Application for DCO by FOSSE GREEN
Representation by Interested Party reference F88728215
Deadline 6

Summary of Submissions

A Comments on REP5A-038- Applicant's Response to Deadline 5 submissions:-

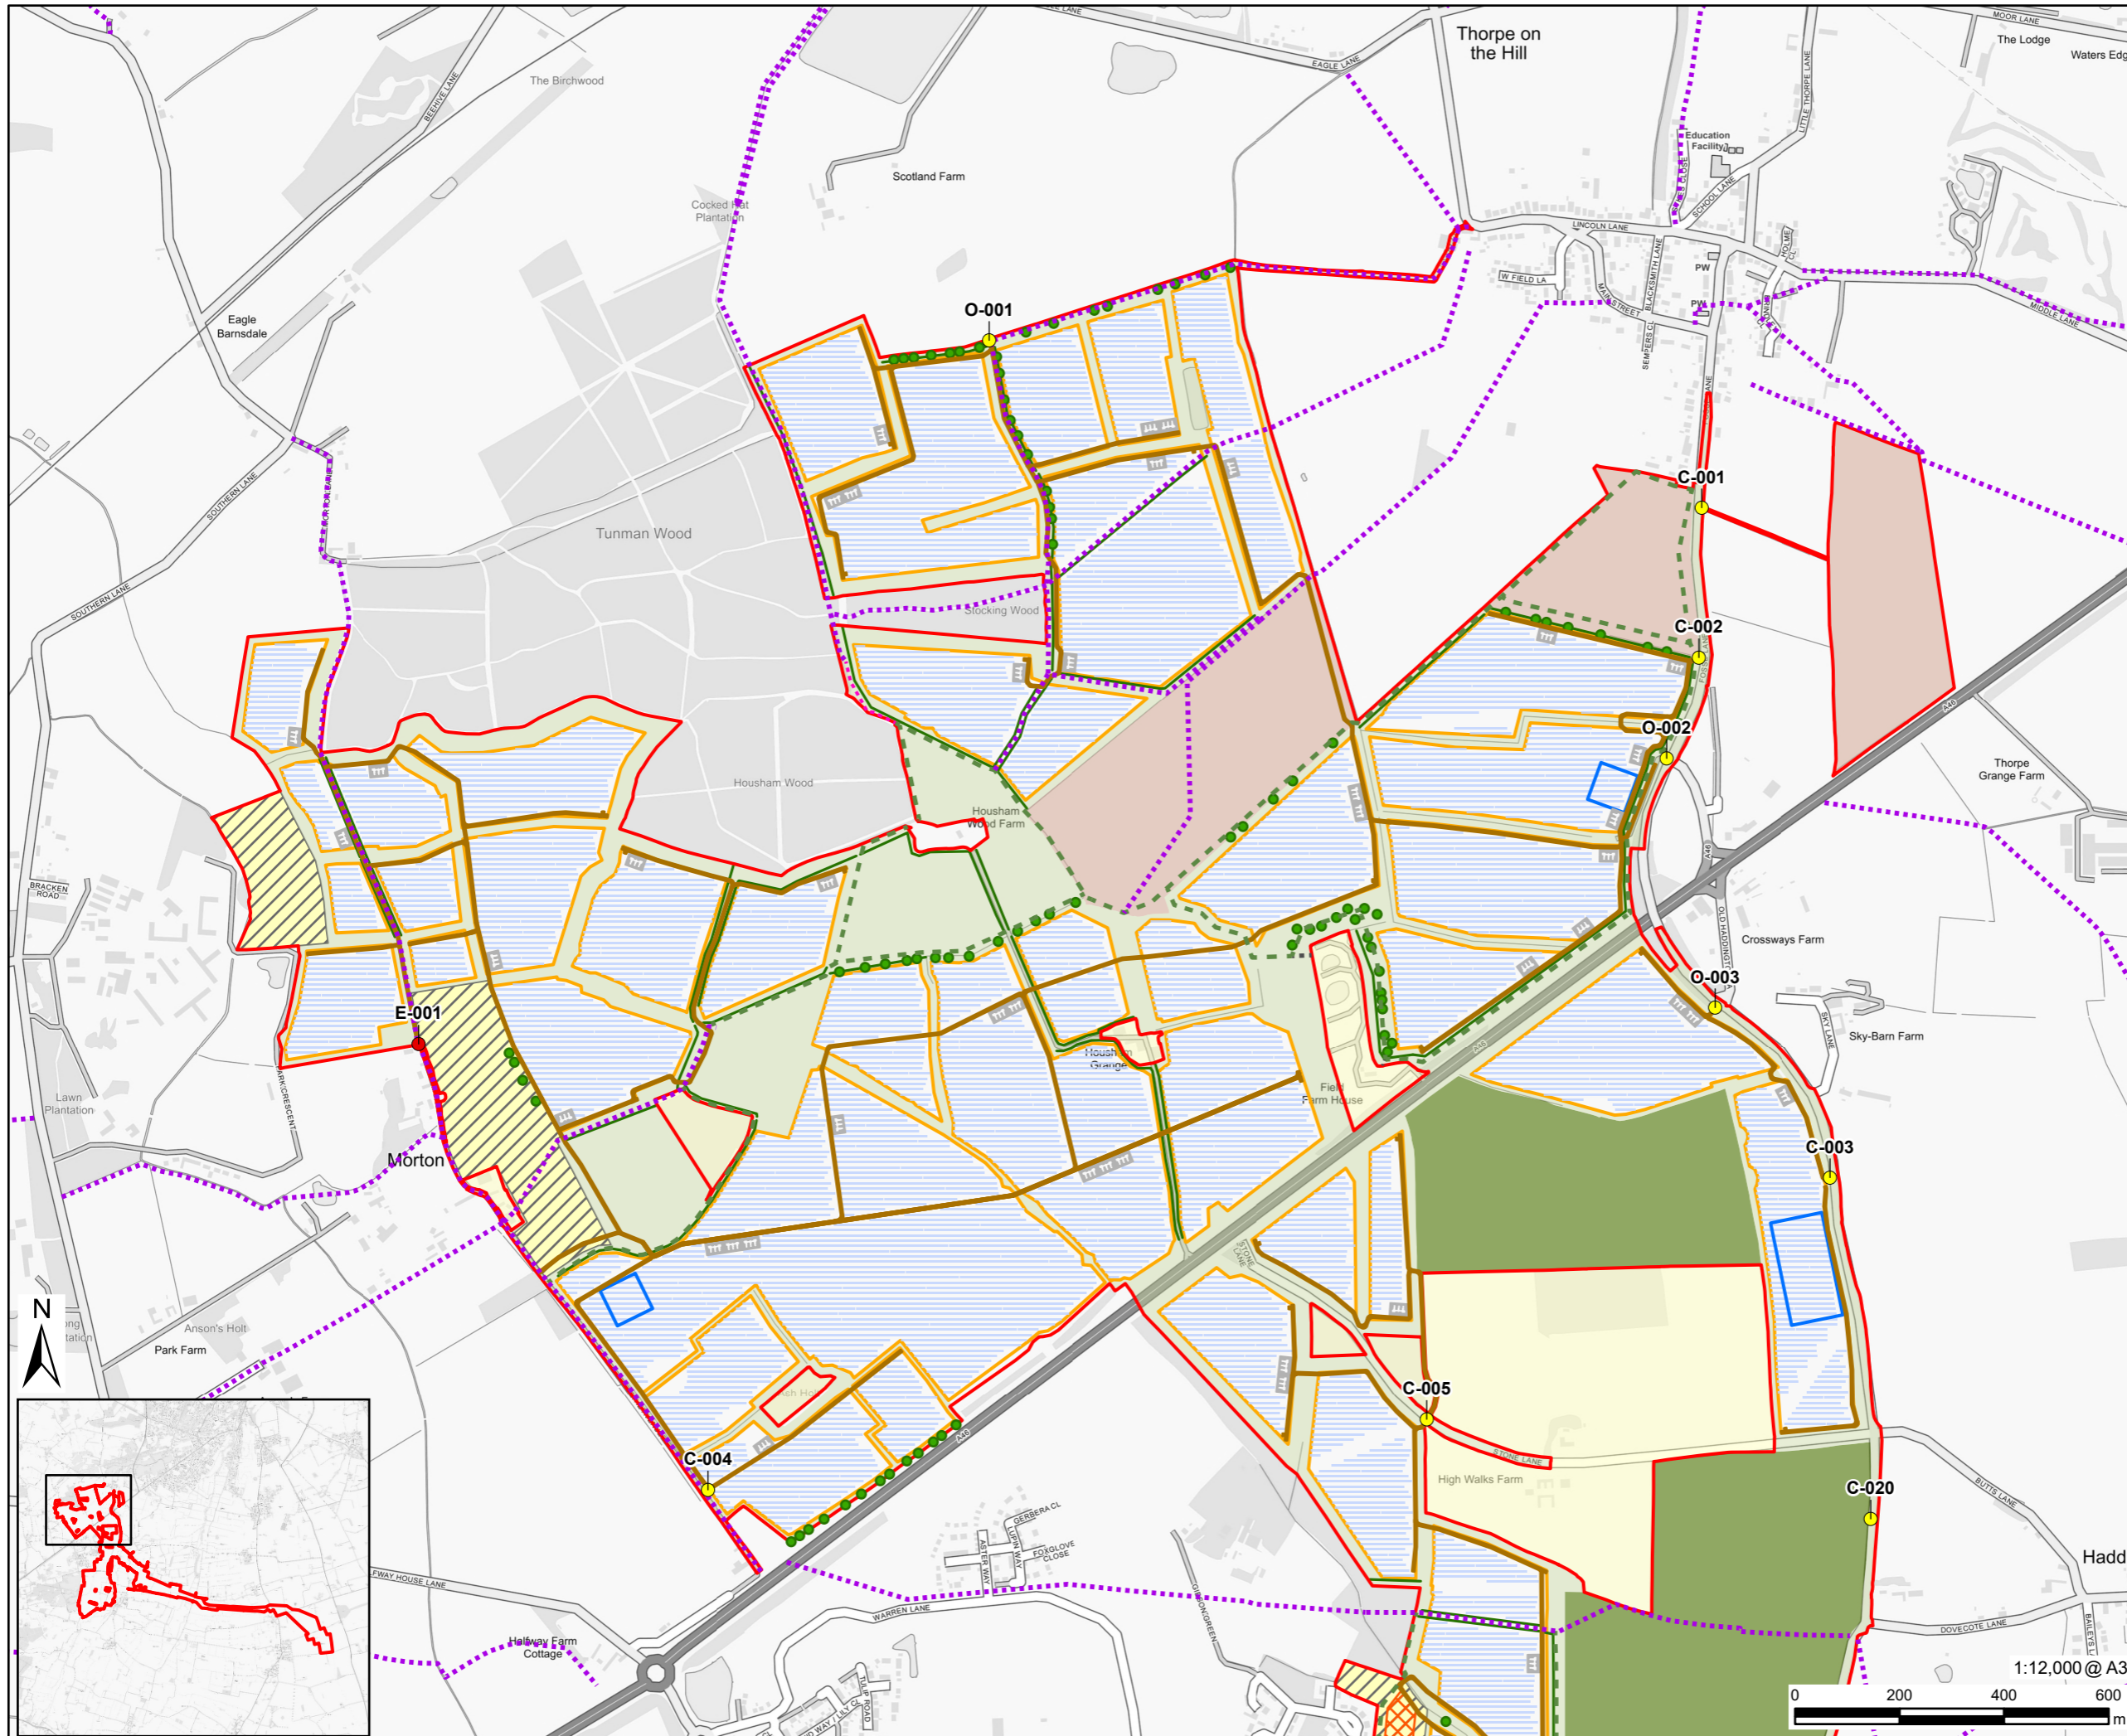
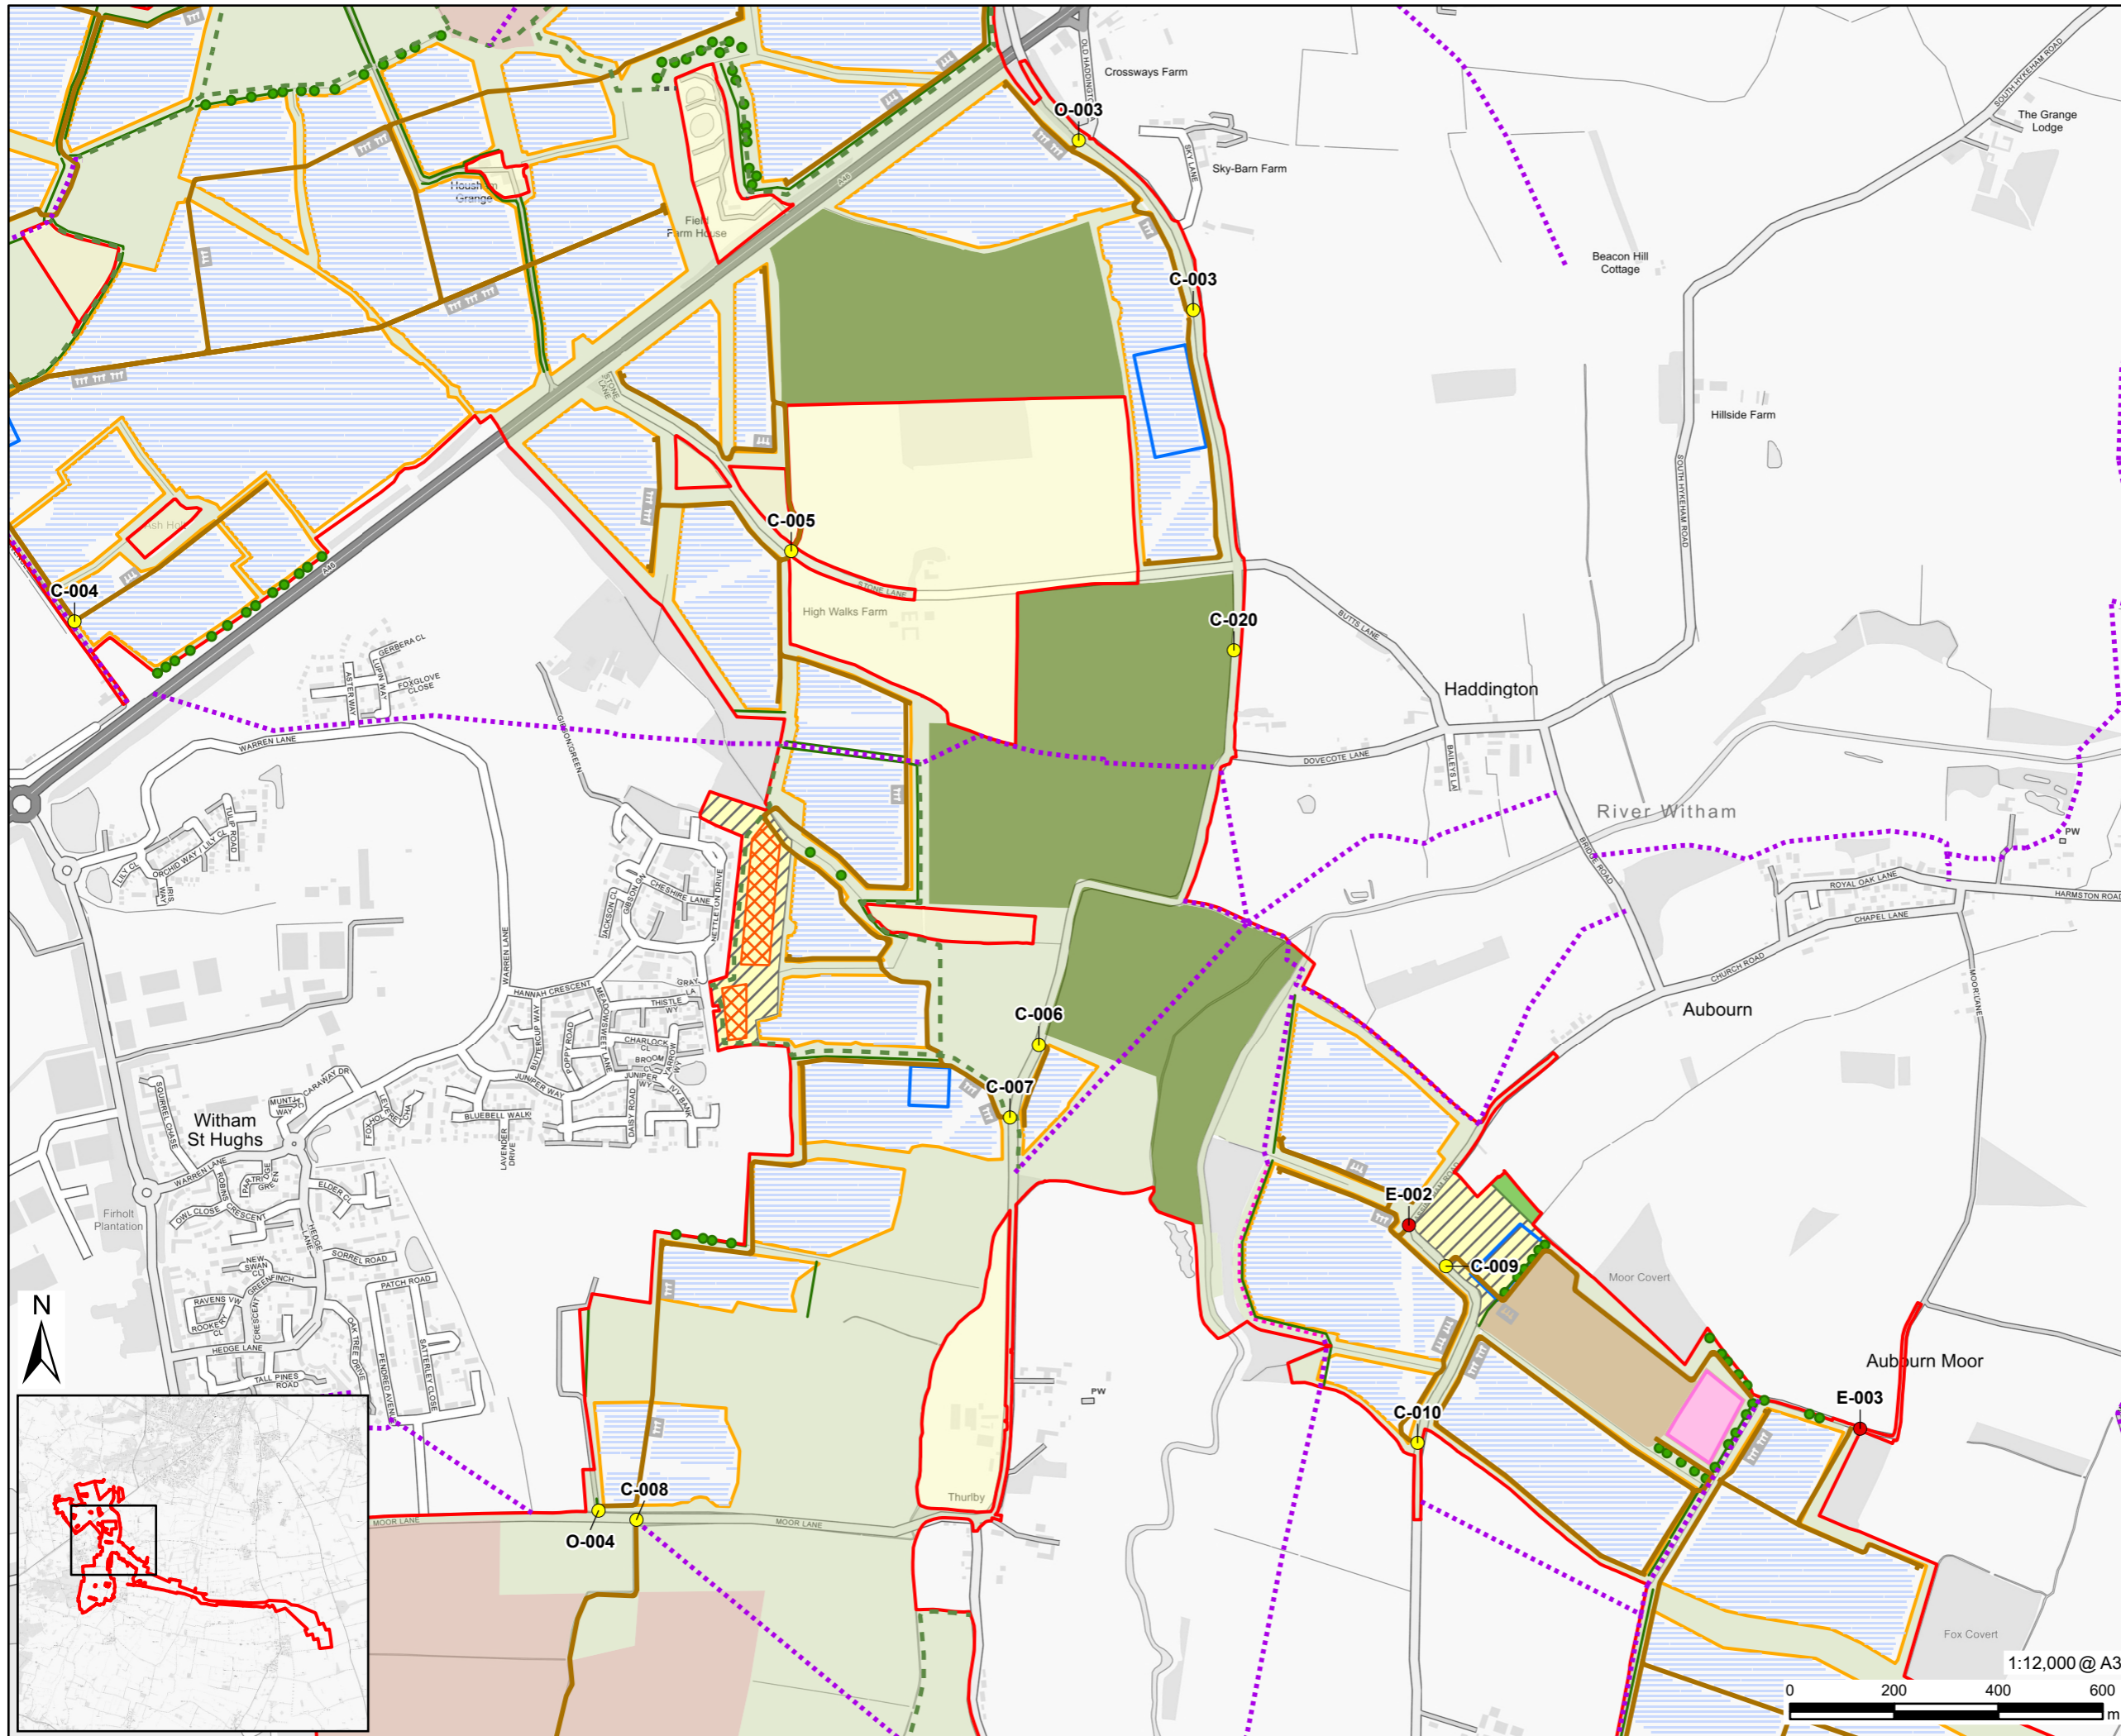
7.2.1 Whilst the Indicative Fixed South Facing Site Layout Plan (REP5-006) and Figure 3-2B Indicative Single Axis Tracker Site Layout Plan (REP5-007) are indicative, it would surely not have been too difficult to show the location of the route of the permissive path so as to be consistent with other plans. Whilst those indicative plans show the permissive path within the highway and the Streets, Rights of Way and Access Plans (REP-004) show the permissive path to the west of the highway, there is a further version shown on the FLEMP Appendix A Figure 7.15.1 (REP5-017) Sheet 9 which shows the permissive path partially within the highway and partially to the west. Three different versions of the route of this path!

Figure 3-2A Indicative Fixed South Facing Site Layout Plan (REP5-006) and Figure 3-2B Indicative Single Axis Tracker Site Layout Plan (REP5-007) are indicative whilst the Streets, Rights of Way and Access Plans (REP5-004) are detailed secured plan showing the proposed permissive path at Clay Lane adjoining the western edge of the highway.
